Ref. Planning Application R/289/17/HH .29 Park Drive .Rustington.

Having inspected the details and drawings of the applicants proposals shown on the Councils web site, we are writing to object to the planning application for an extension to the rear of the property.

PROPOSED ELEVATIONS 1:100

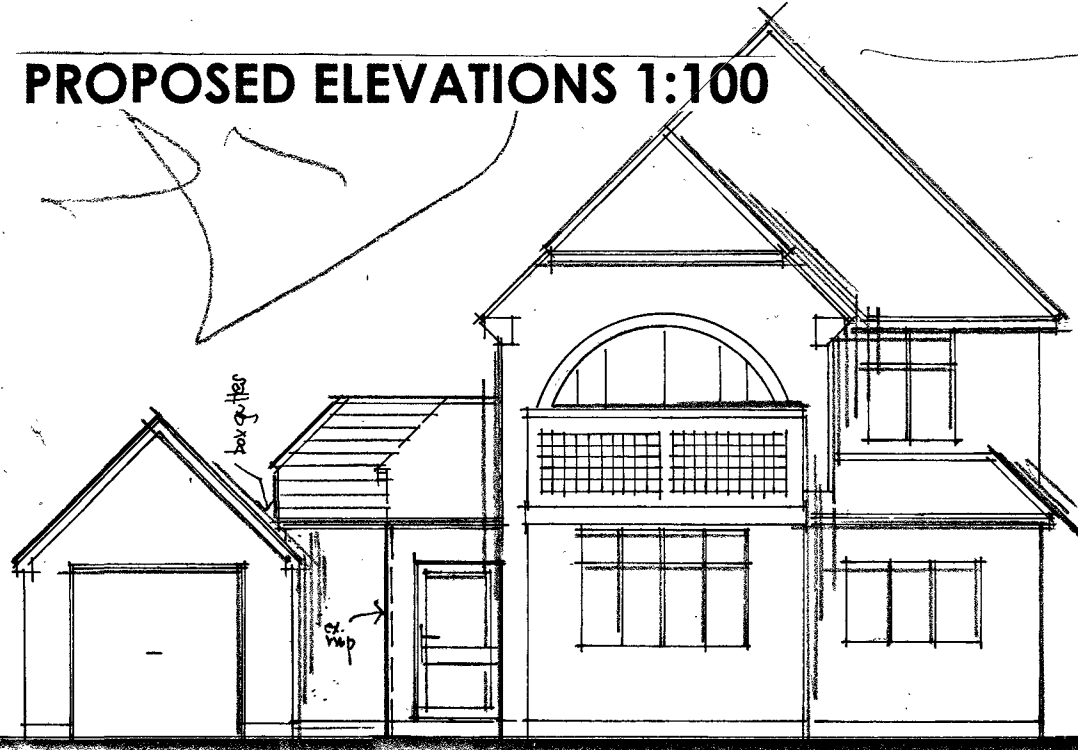
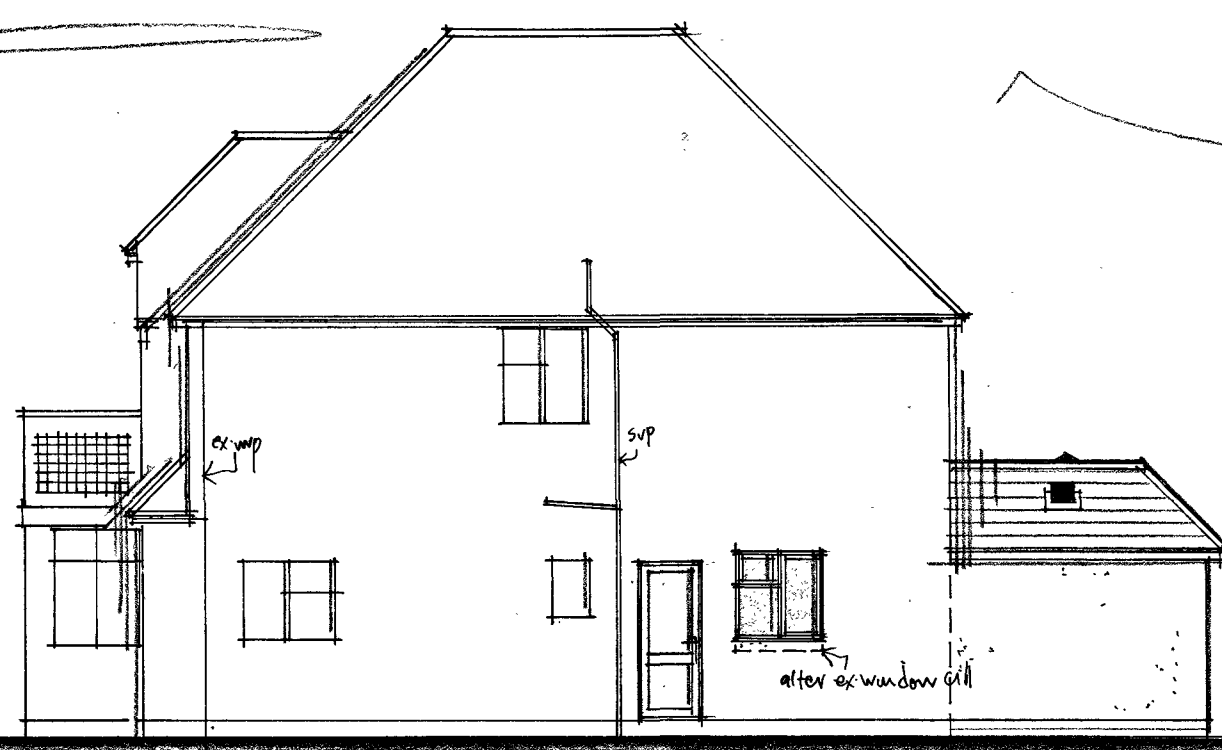
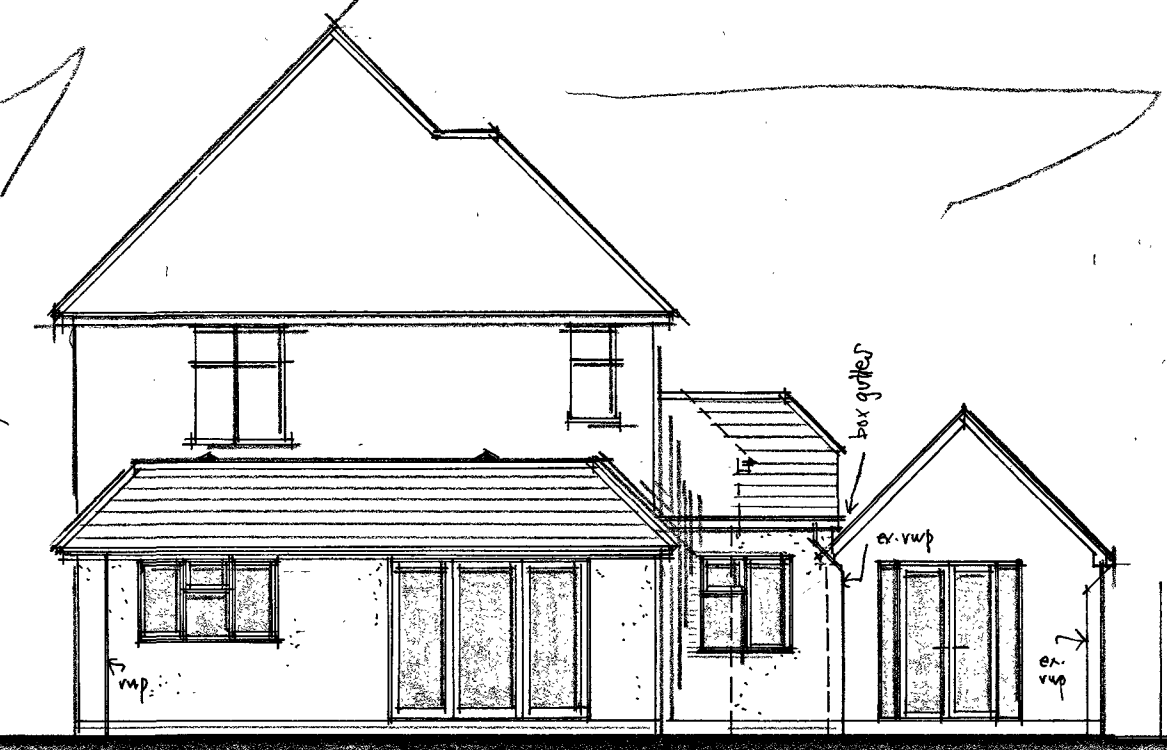
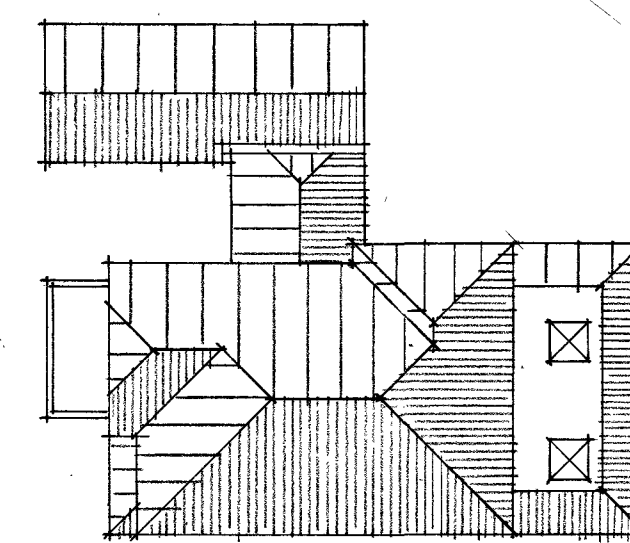
i) **LOSS OF DAYLIGHT/ AMENITY** – The increase of the footprint together with the increase of the roofline {the height of which is not shown on the drawings} would result in loss of light to our garden causing loss of our amenity and enjoyment of our home as the existing footprint of property already extends 4 metres, well past our dwelling. We need to emphasize this as all our gardens face north therefore the sunlight is from the west and with this large extension half way down length of the garden and only 1.3 metres from the boundary we will not get any sunlight at all into our garden which we are certain is a contravention of the Arun District Local Plan 2003 policy GEN 7 item (ii), (iii), (iv) and policy 2 of the Rustington Neighbourhood Plan September 2014

ii) **OVERBEARING DESIGN** - As previously stated. As the existing property already extends well past our dwelling a further 3.375 metre development and only 1.3 metres from the boundary with a false pitch roof {the height of which is not shown on the drawings} on the scale shown on the registered plans would mean it would be totally overbearing and visually intrusive to our property as it would extend half way down our garden. Again in contravention to the Arun District Local Plan 2003 policy GEN 7 item (ii), (iii), (iv) and policy 2 of the Rustington Neighbourhood Plan September 2014.
